Planning Application Ref: BN/57/19/RES

Location: Land East of Fontwell Avenue, Fontwell Avenue, Fontwell, BN18 0SB

Description of works: Approval of reserved matters for 3785sqm of light industrial floorspace (Class B1 (b)/(c)) following the grant of WA/22/15/OUT

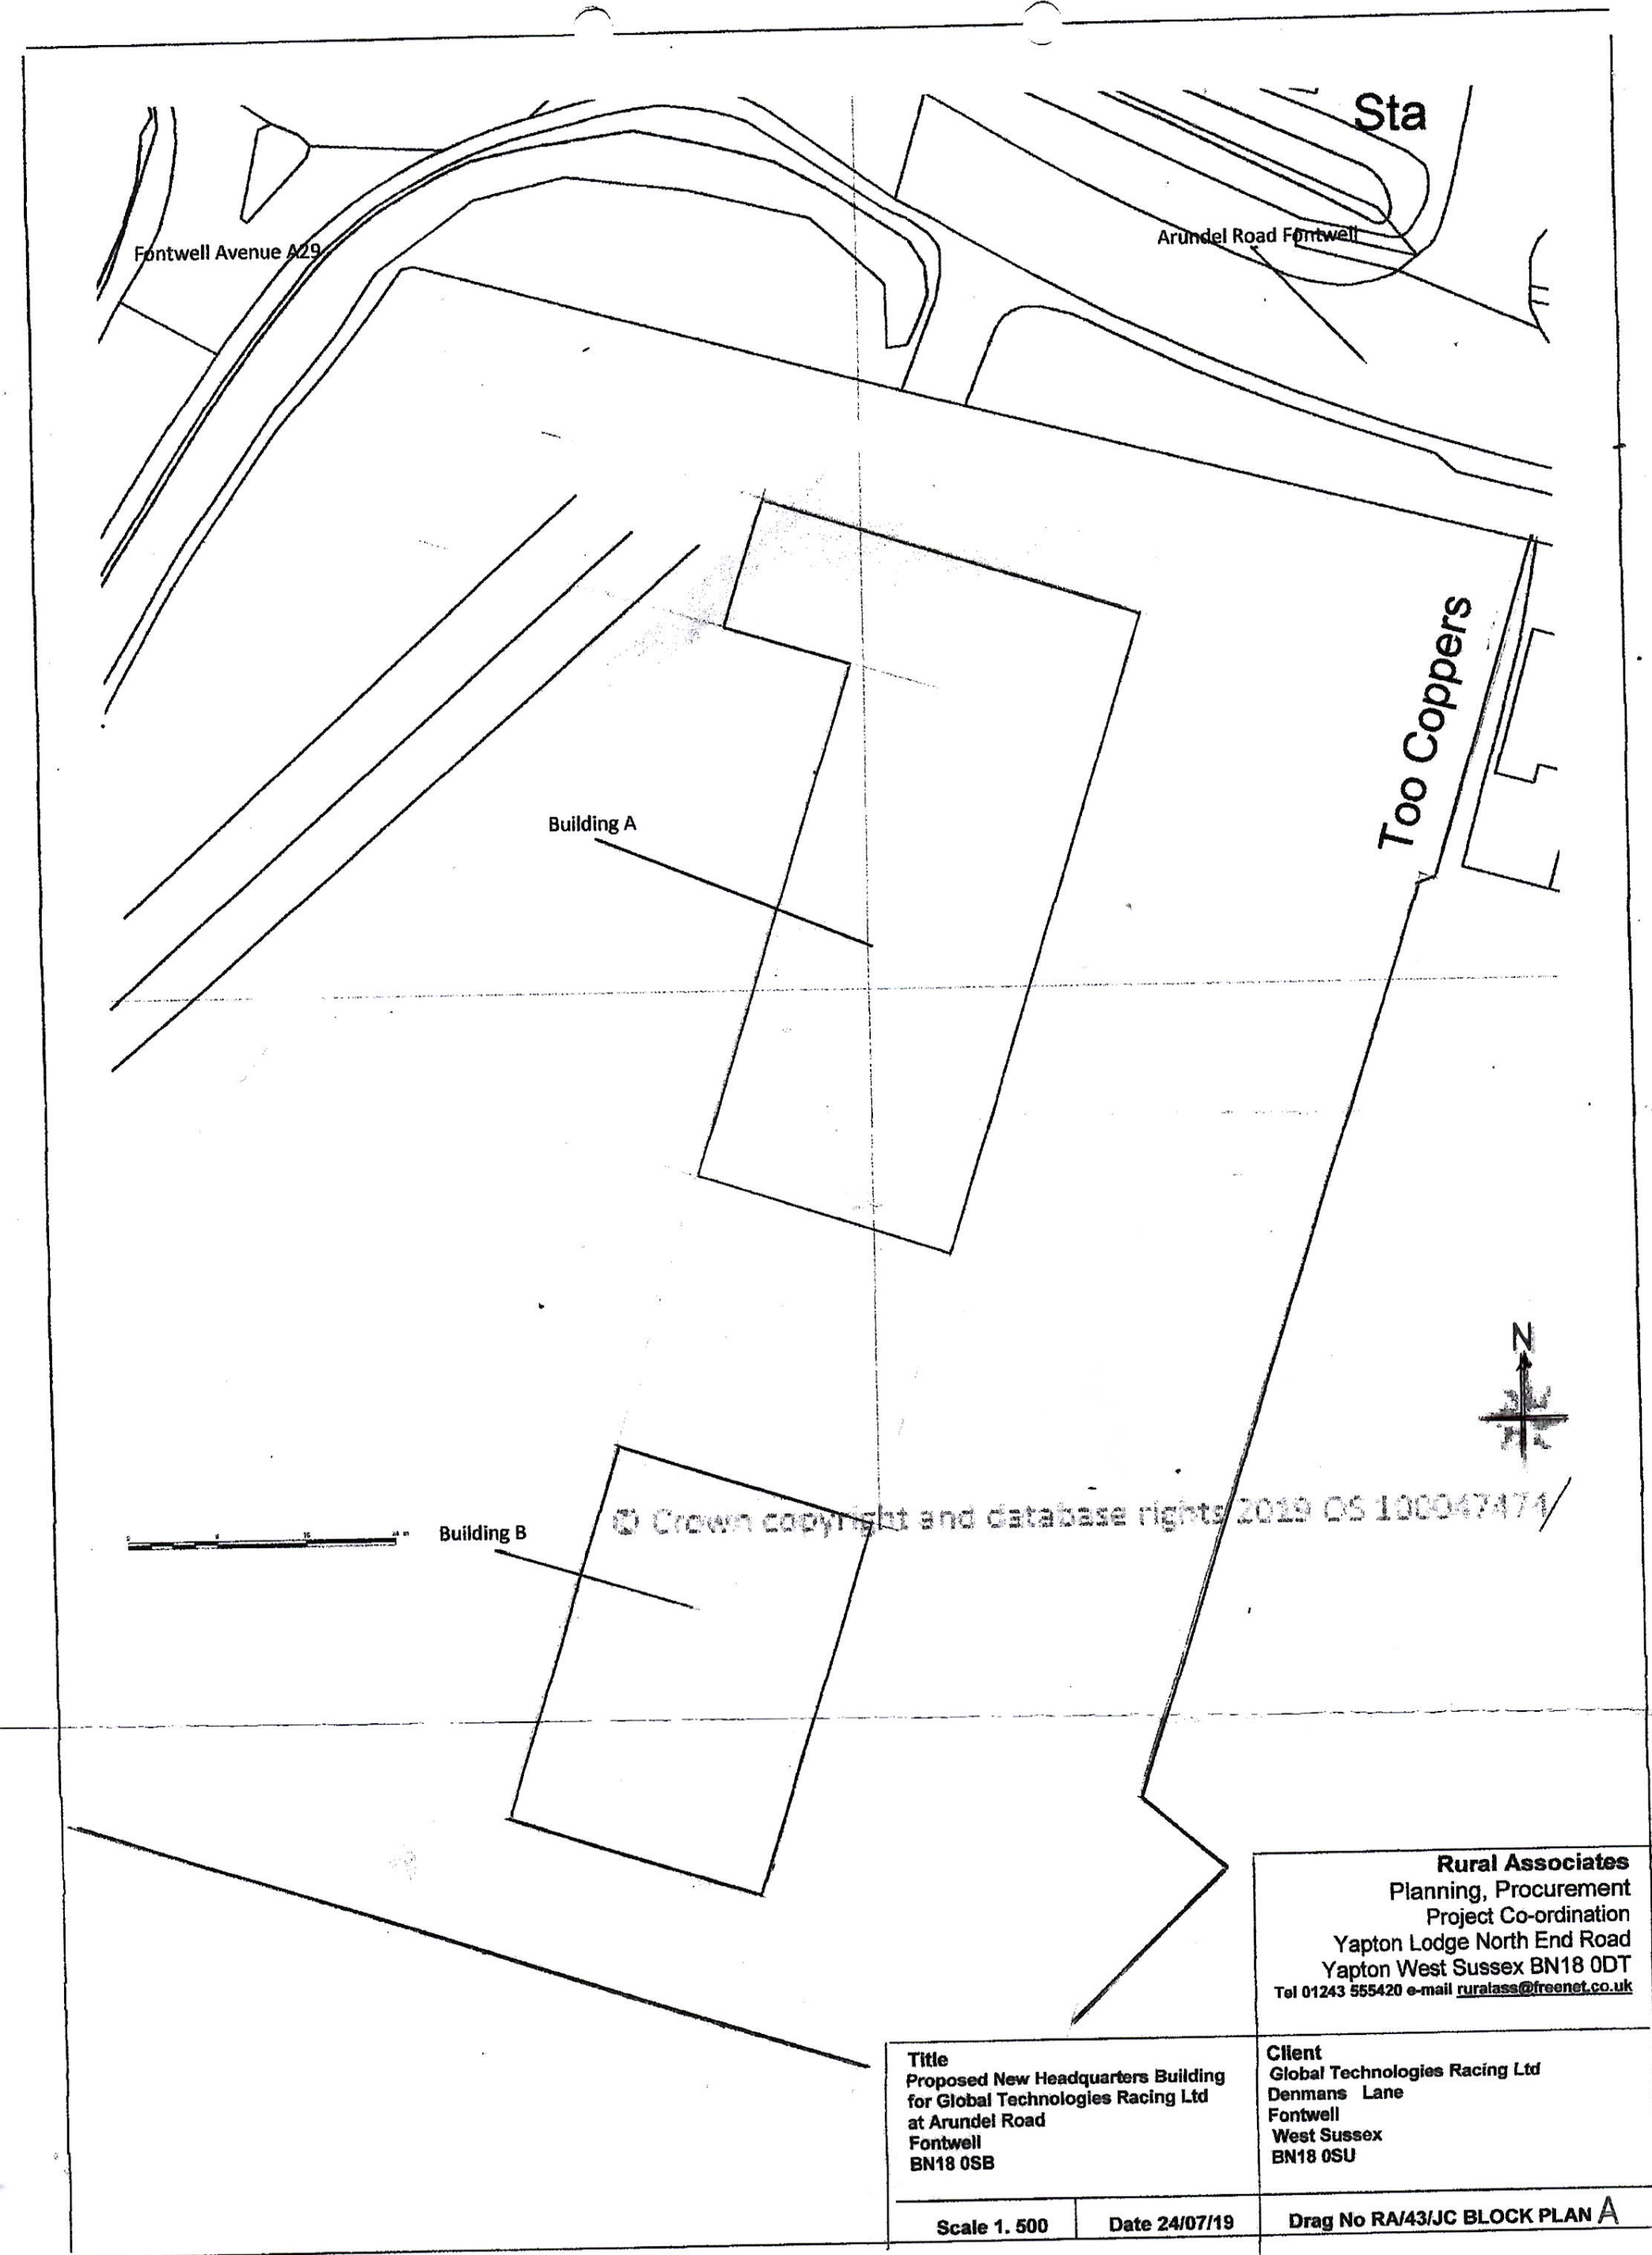
- **Unit B. Proximity to tree group (T1-T6)** precipitates the removal of all but one tree – T3 Oak, the most valuable tree wholly within the site, which would be partly obscured and subject to root and crown interference. Furthermore, it will not have enough room to flourish and achieve full growth potential. I have no strong objection to removal of the other five trees, but the trade-off must be to fully respect and promote the oak.

- **SW corner of site (T8 & T9)** appears to involve RPA intrusion by way of footway construction. If the broken line denotes such a feature, then there appears to be ample room to locate it beyond a revised RPA (polygon) which abandons the inclusion of carriageway/footway and captures enough of the existing verge and field to be contingent with the area of a pre-calculated circular RPA.

- **W boundary of site (T11)**. Unjustified intrusion into RPA of significant tree with high growth potential.
- **W boundary of site (T13-21)**. Potential conflict with 10m easement required around SUDS feature. Trees of high growth potential.

- **NW corner of site (T26-T31 and T40-T46)**. Unjustified removal of native trees with high growth potential and creating a gap in the established tree-line.

- **Main access**. Can this not be located elsewhere on the northern boundary, such as the existing route into the field or where the risk of damage to higher value trees is considerably less? If not, then a 'No-dig' construction specification must be employed within tree RPAs.

- **NE corner of site (T67)**. I would not support any development beneath the canopy of a mature Monterey pine, least of all a late-mature example of such size and condition. The risk of damage from falling cones and branches is unacceptable in my view. I also consider there to be unjustified intrusion into the nominal circular RPA and suggest that row of parking bays at least, is abandoned and left to unmade ground.
